From: Neil Whitton  
Sent: 23 November 2020 11:13  
To: Bernadette Owens <Bernadette.Owens@Cherwell-DC.gov.uk>  
Cc: DC Support <DC.Support@cherwell-dc.gov.uk>  
Subject: 20/02779/REM - Land Adj To Promised Land Farm

Environmental Protection has the following response to this application as presented:

JOB TITLE		CATALYST BICESTER		CLIENT		ALBION LAND	
DRAWING TITLE							
RESERVED MATTERS 1 ACCESS & LAYOUT REVIEW							
SCALE	DRAWN BY	DATE	DRAWING No	REVISION			
1:250@A1	RJM	05/08/20	19539-20	A

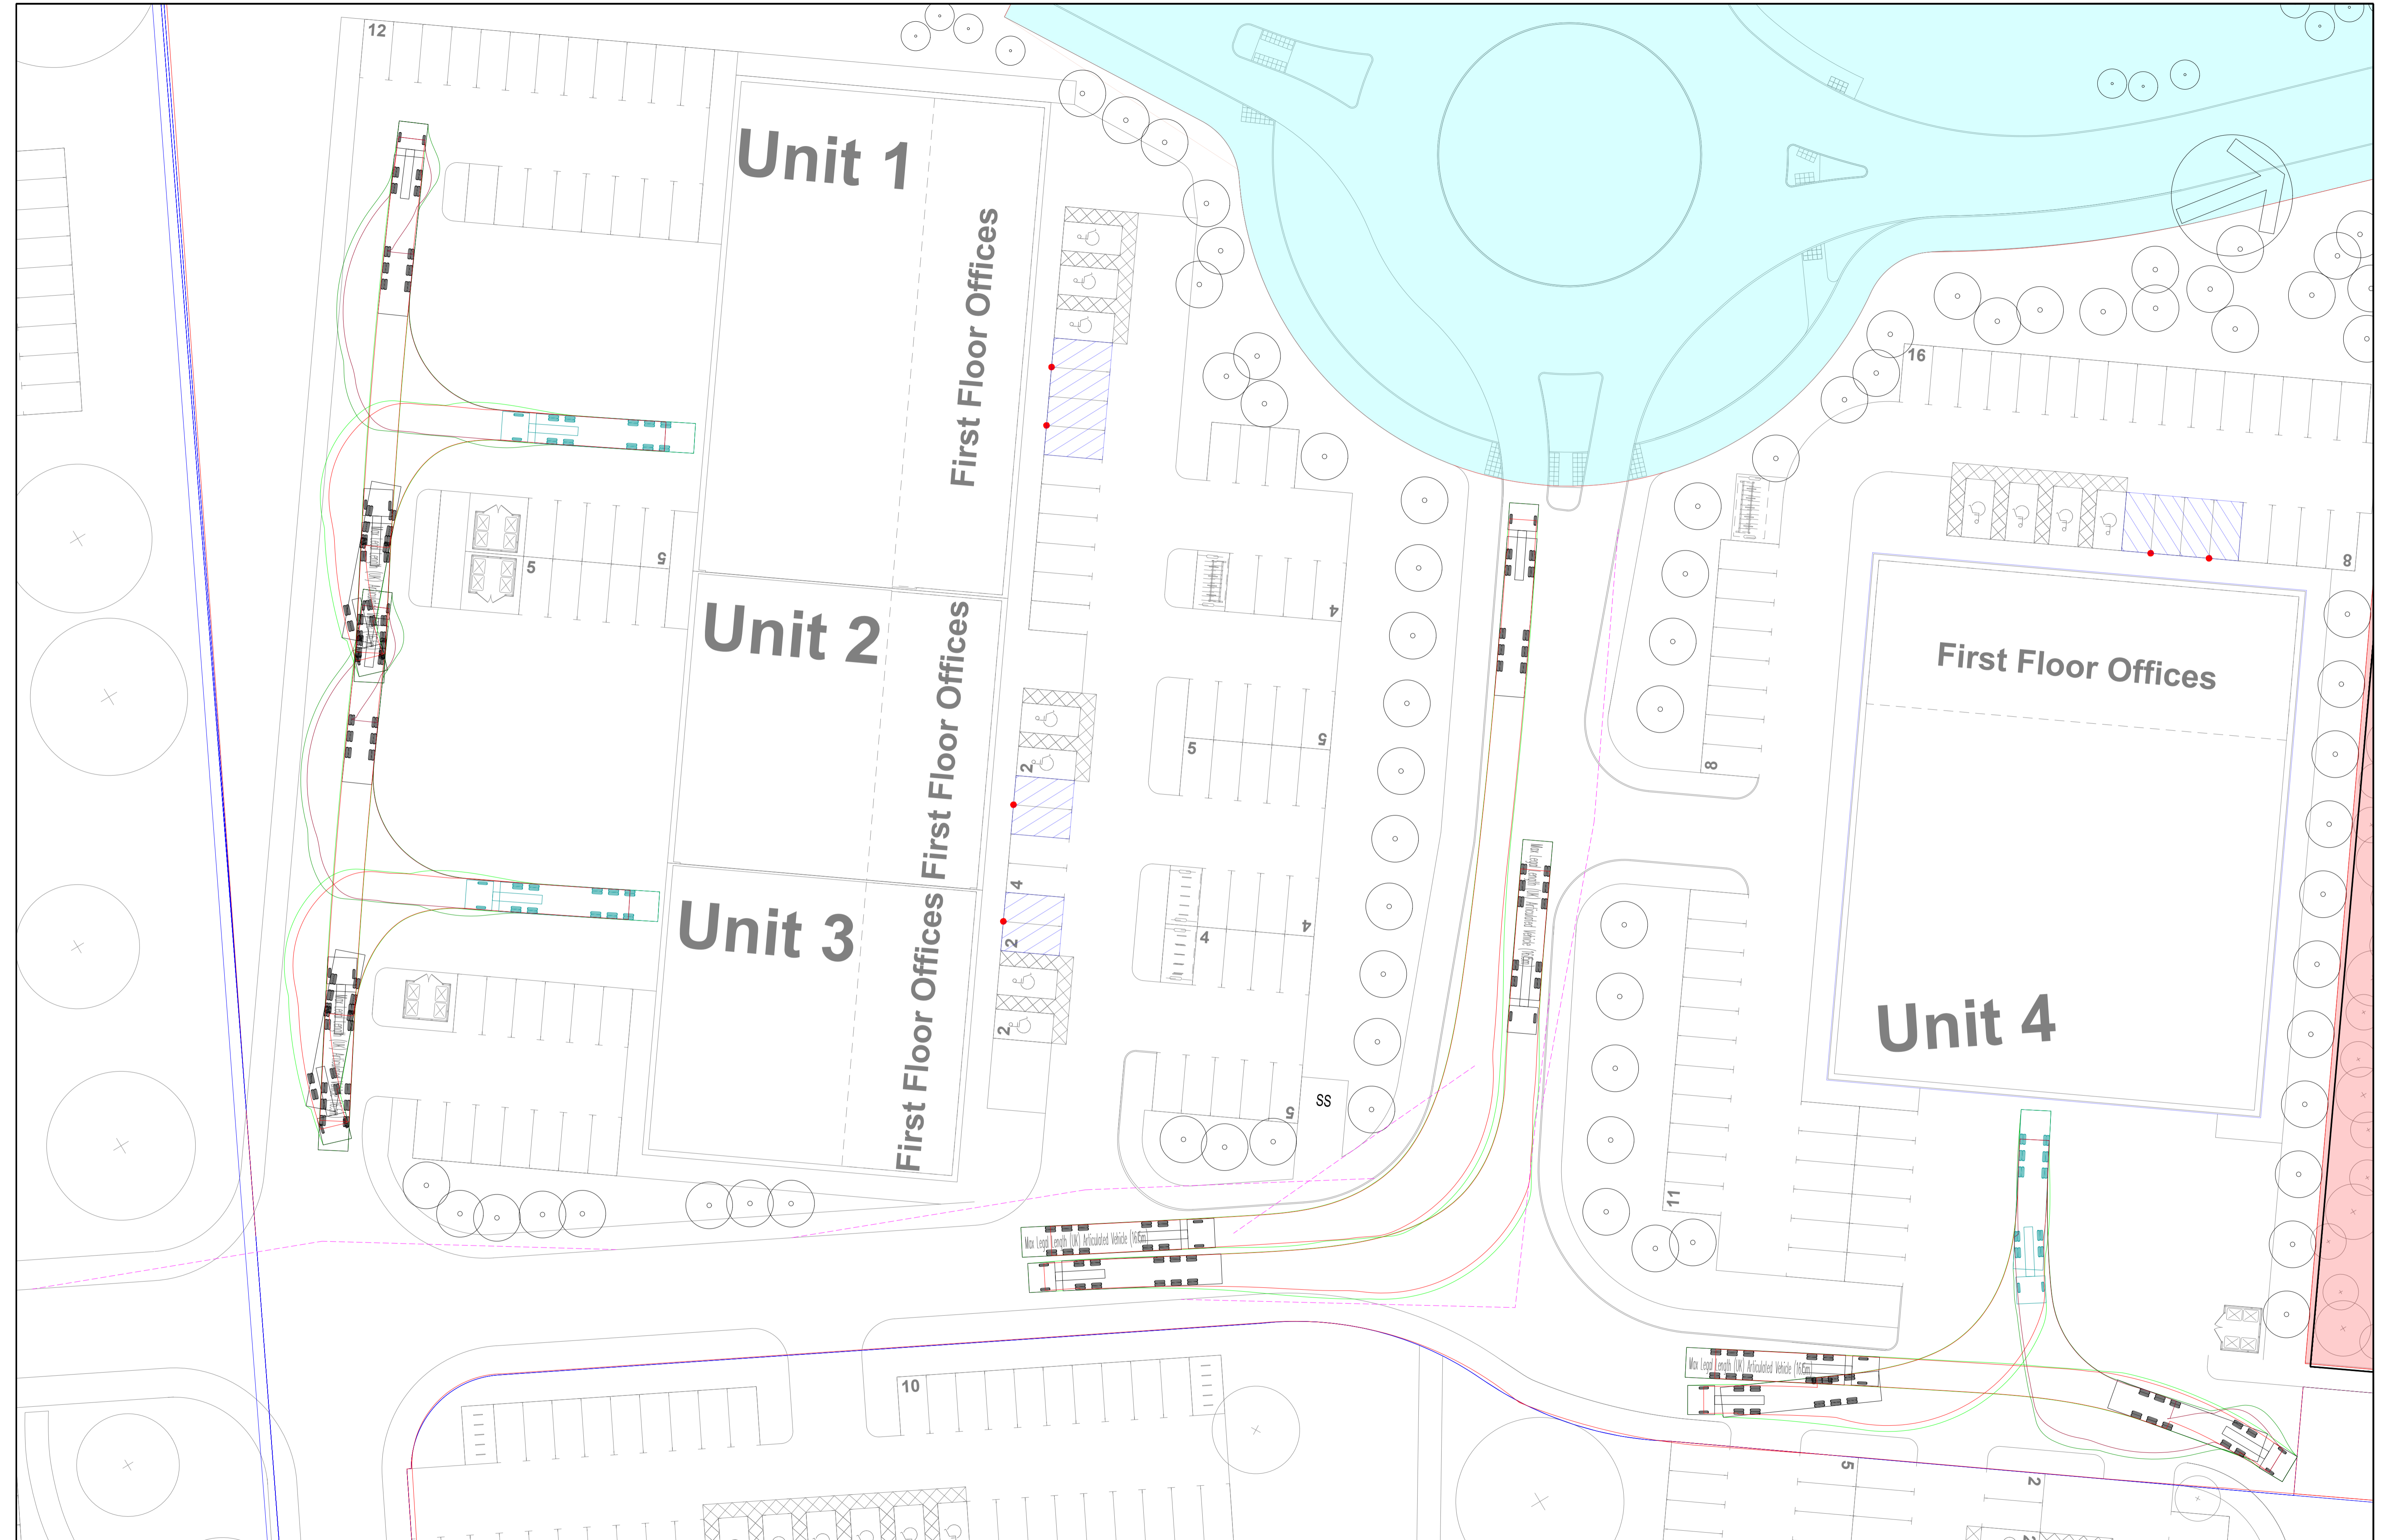
Air Quality: I am assuming that the blue spaces on the plan attached to the parking note are denoting EV charge points? I am unable to find a legend or note regarding these spaces? There is also no mention of ducting to allow for the increase of EF charge points when demand increases. In light of the recent government proposals to bring forward the banning of new ICE vehicles to 2030, this should be an important part of planning for any new development now.
